RE: SSI - 4951 WINDSOR BRIDGE REPLACEMENT PROJECT – PUBLIC EXHIBITION OF THE ENVIRONMENTAL IMPACT STATEMENT

This letter has been prepared following review of the documents forming the Environmental Impact Statement for the replacement of the Windsor Bridge. The review has been undertaken by a Heritage Council Sub-Committee formed specifically for this project assisted by Heritage Branch staff. The Committee met on Tuesday 11 December 2012 to finalise these comments.

Figure 5-1a | Key project elements - Southern Approach

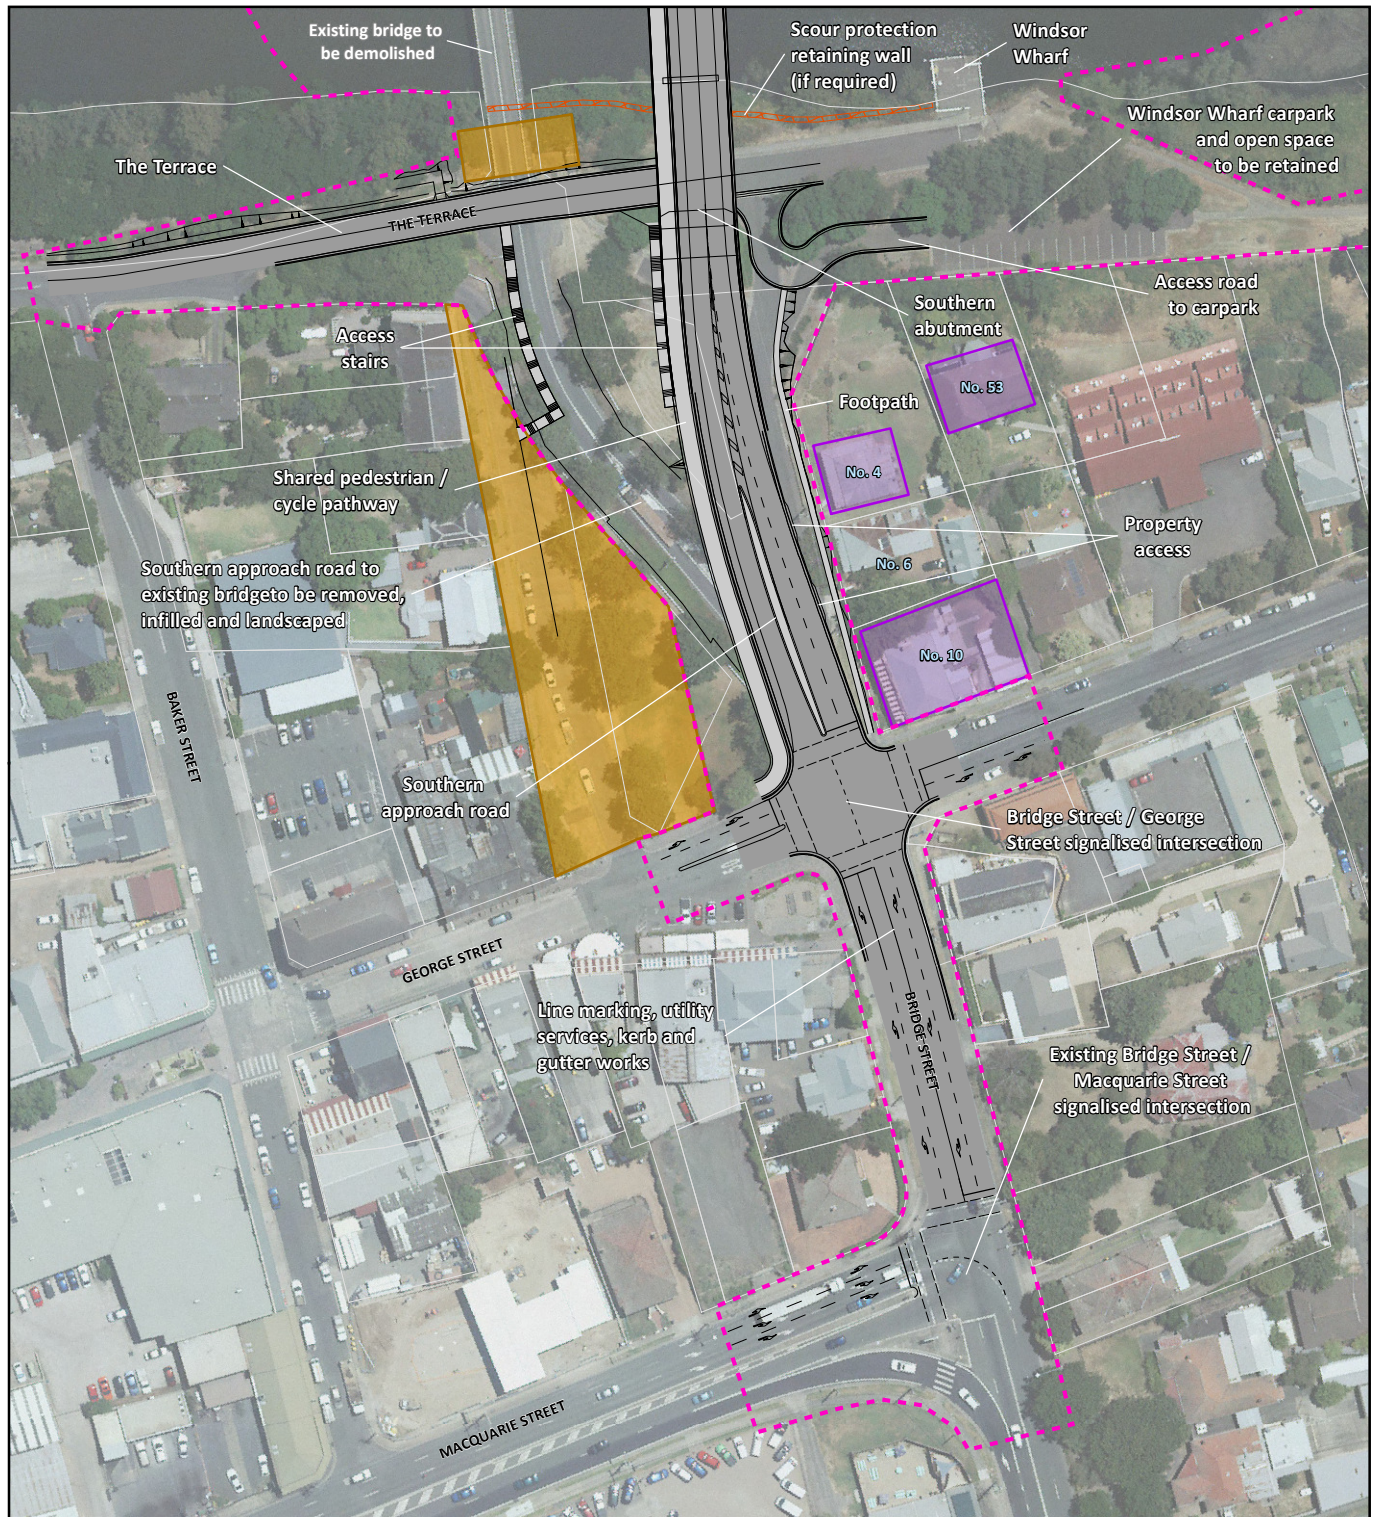
The proposed road plan is inelegant and unresolved – it is too close to significant buildings, too wide particularly where the slip road is proposed, and does not show any subtle balance between traffic space, pedestrian space, landscape and the physical definition of this very important square. The traffic planning and road alignment appear to have been determined by traffic considerations and codes only. Successful squares often have traffic in them but there is a balance between built form, 'hard' landscaping and soft landscaping.

There has been inadequate recognition that the State Heritage Register listing for the Square includes the open space and all of the buildings which surround it. Thus the relationship not only within the open space, but between the buildings and the Square, or the entire setting of the Square is of importance. The placement of a new major road along the

side of Thompson Square will sever the relationship between the buildings along Old Bridge Street to the Square, and also with the buildings on the opposite side of the Square.
